Recommendation Report for Planning Permission for Works or Extension to a Dwelling

REF NO: P/75/21/HH

LOCATION: 86 Pagham Road
Pagham
PO21 4NN

PROPOSAL: Erection of single and two storey rear extension.

PROPOSED GROUND FLOOR PLAN

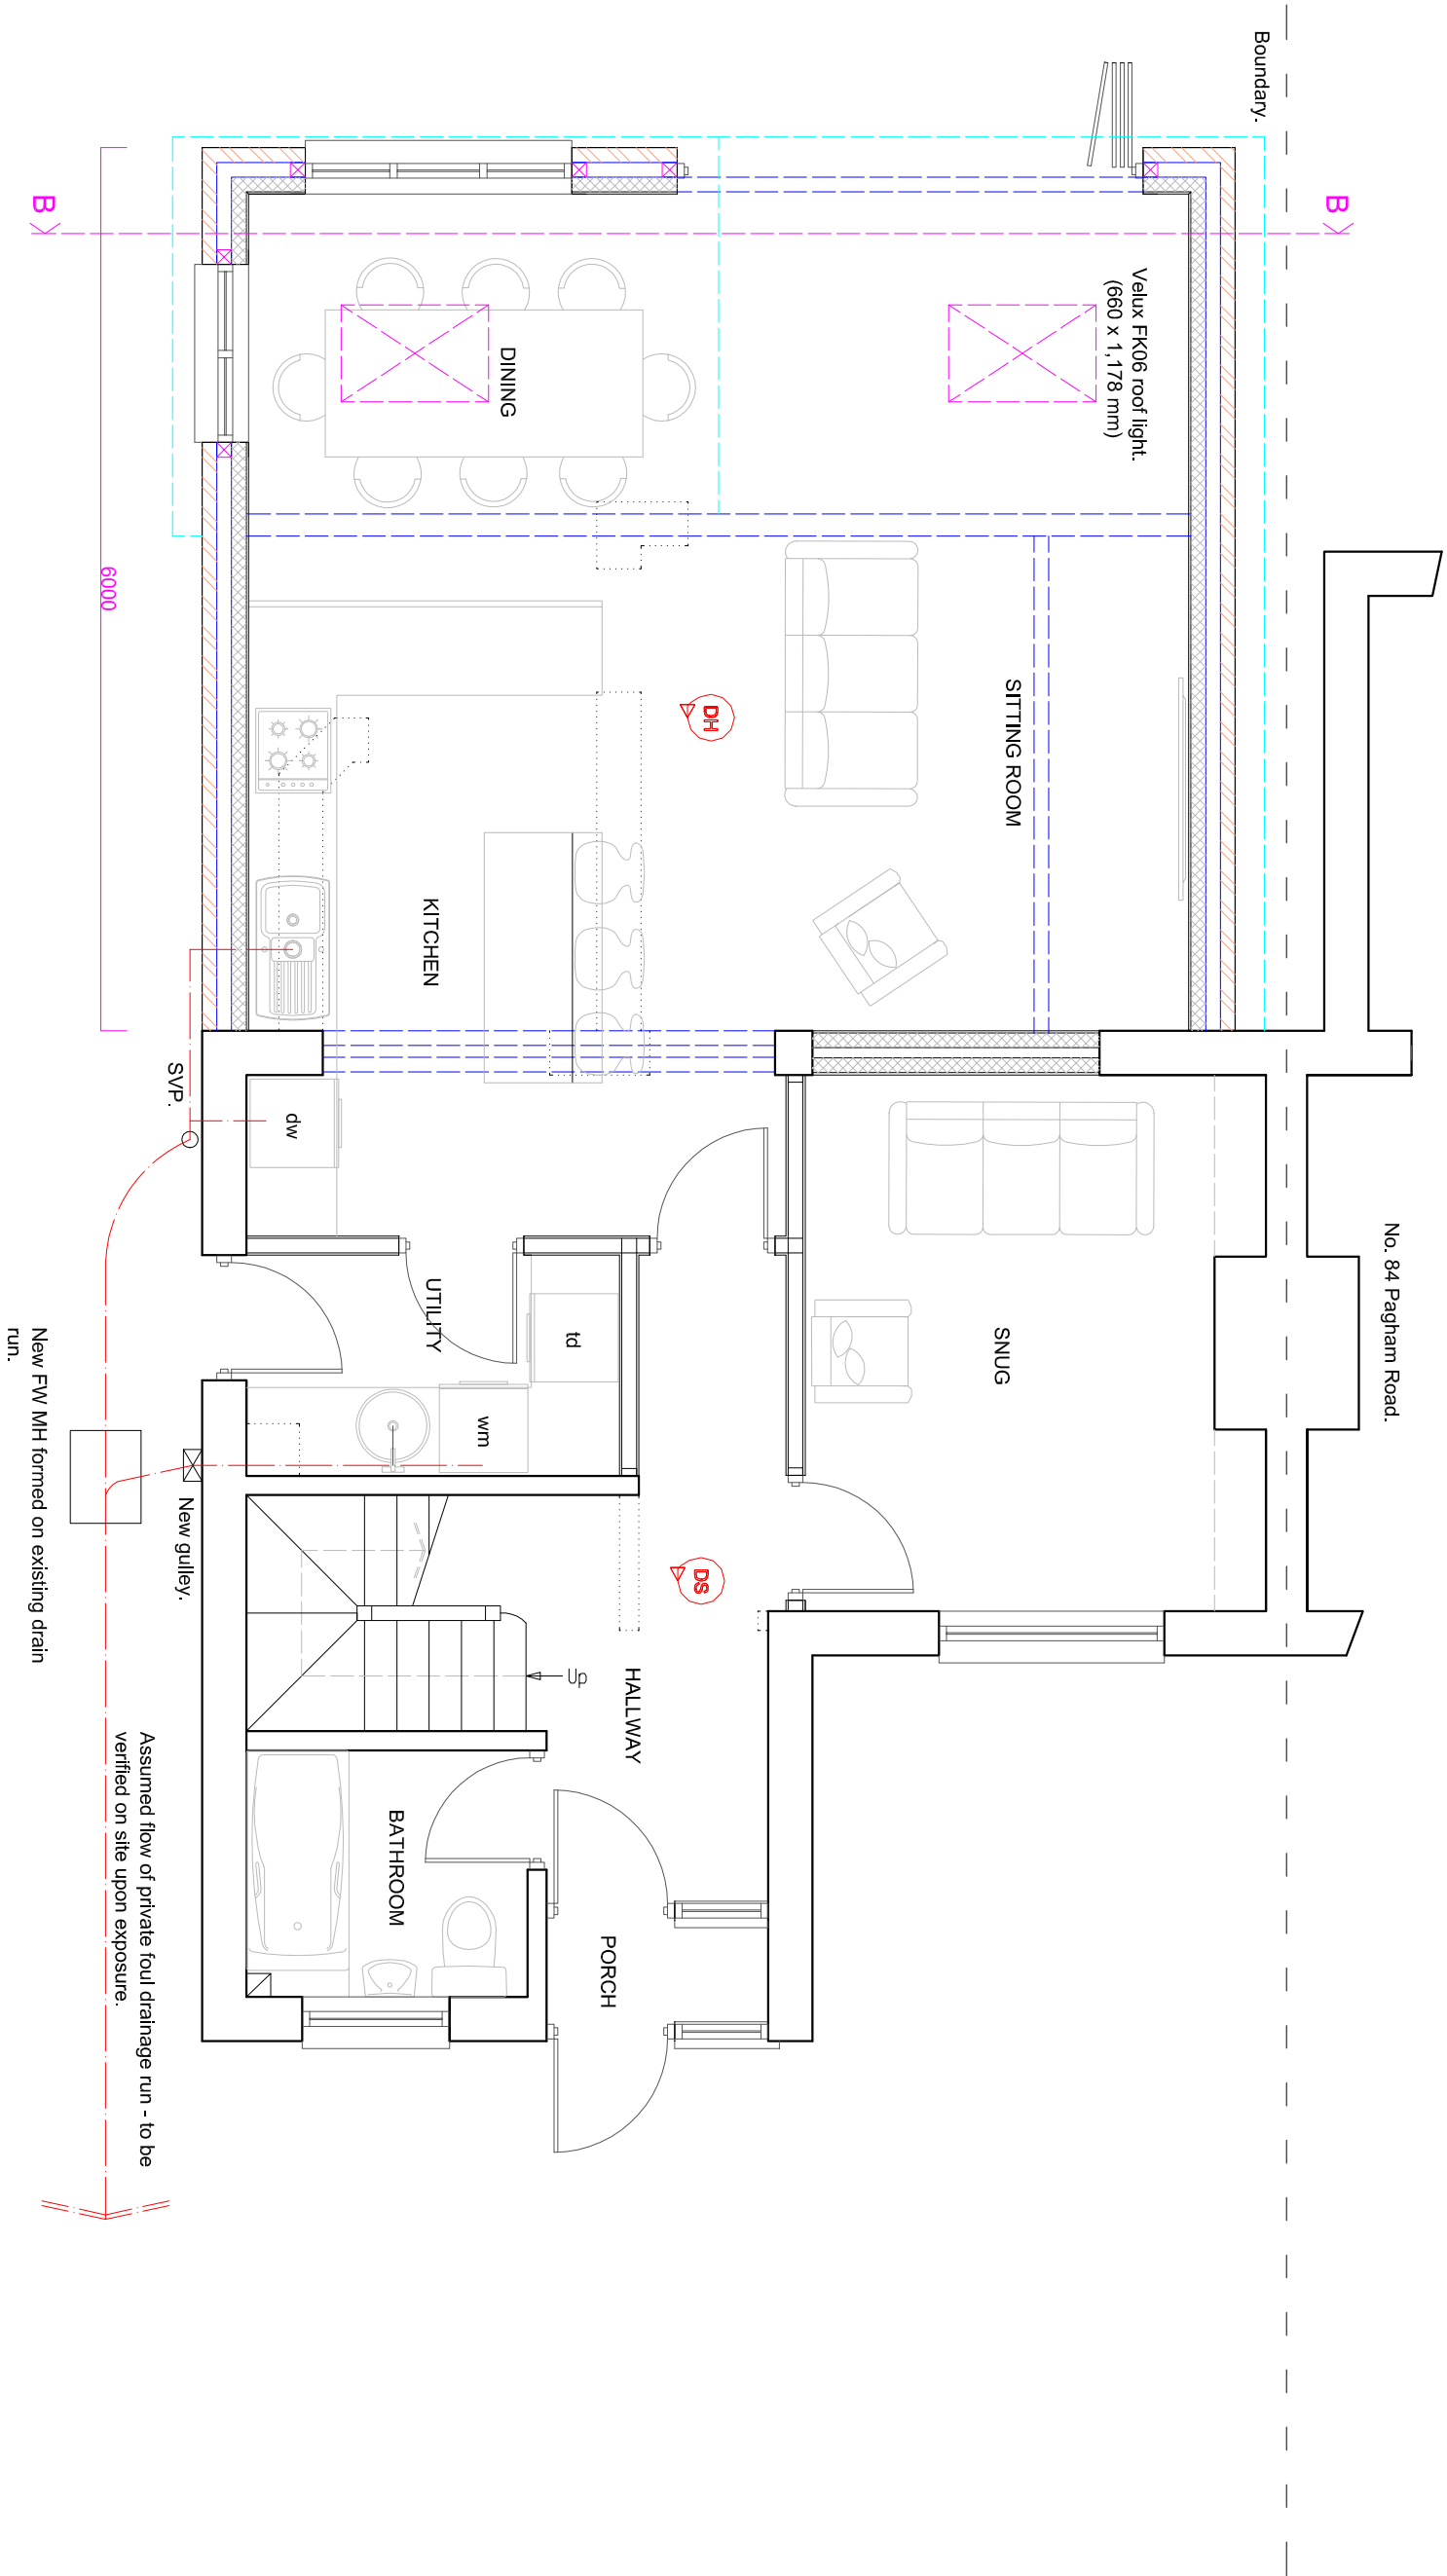
The proposed single storey aspect will intersect the 45 degree angle from the neighbouring property but due to the eaves height of the proposed being lower than that of the neighbouring extension it does not cause harm demonstrable to the application with the pitch away from the boundary the harm is further reduced.

PROPOSED ELEVATIONS

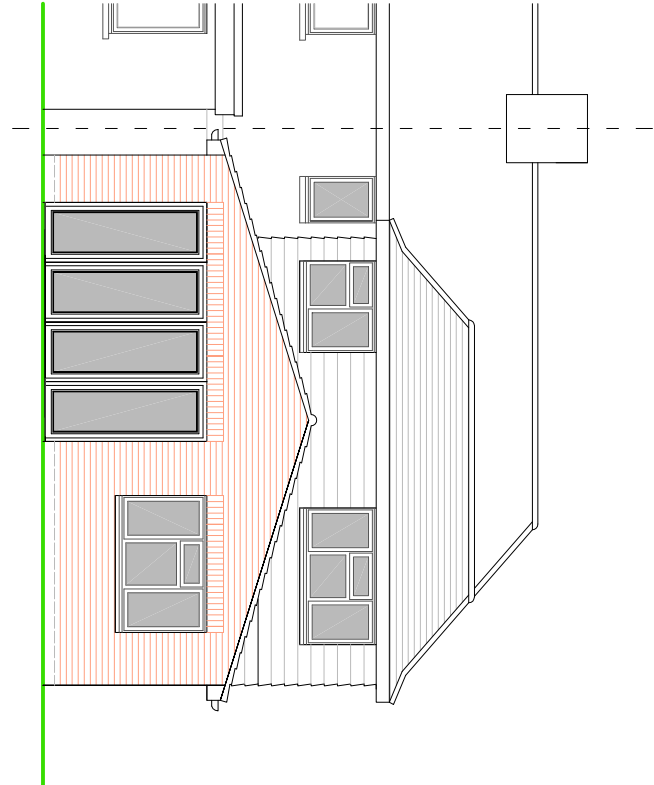
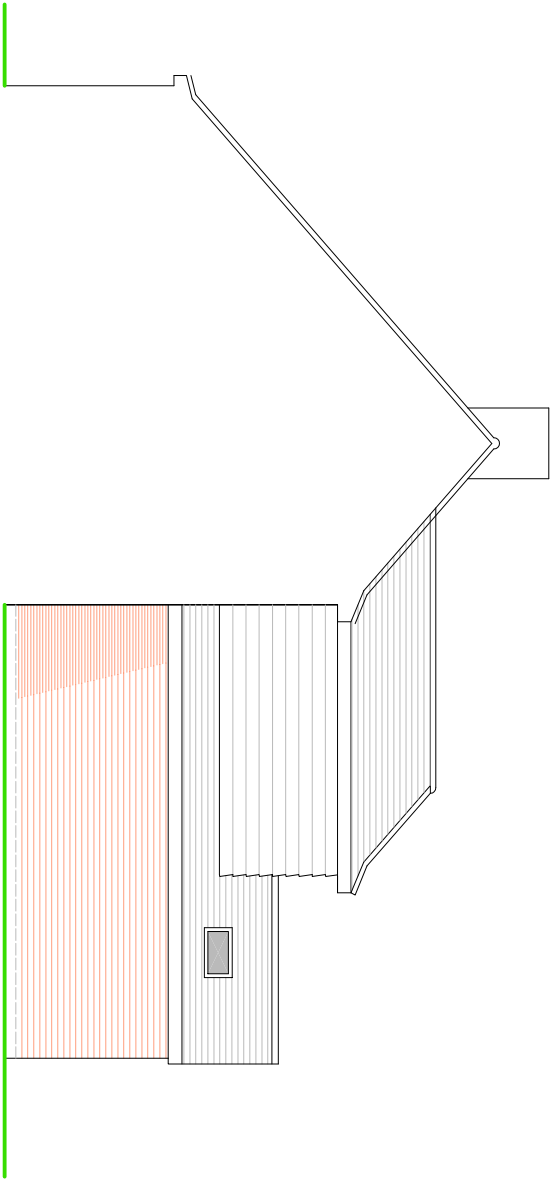
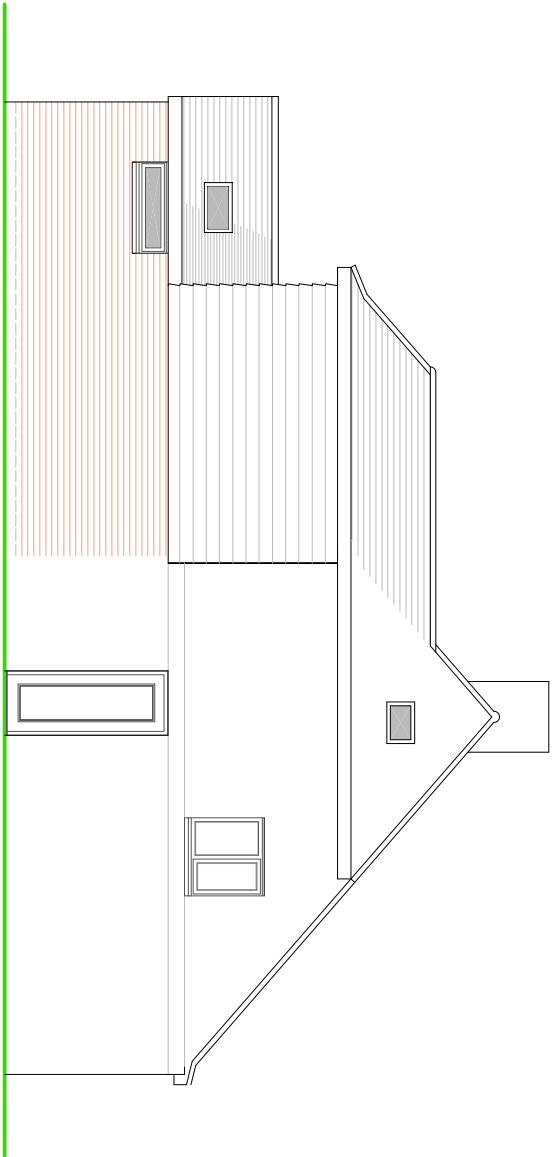
The main footprint and height of the rear two storey extension which will top a single storey aspect to the proposal. The two storey aspect will have a roof height 0.85m below that of the of the main dwelling, therefore allowing the extension to be well integrated into the existing dwelling as well as being able to be considered subservient.

The proposed windows on the rear elevation on the first floor will result in no adverse effects by way of overshadowing or overbearing effects on the neighbour to the east due to the separation distance. Overlooking of the neighbours is also mitigated through the lack of windows on the side elevations ensuring views gained over the neighbouring properties is not justification for refusal.
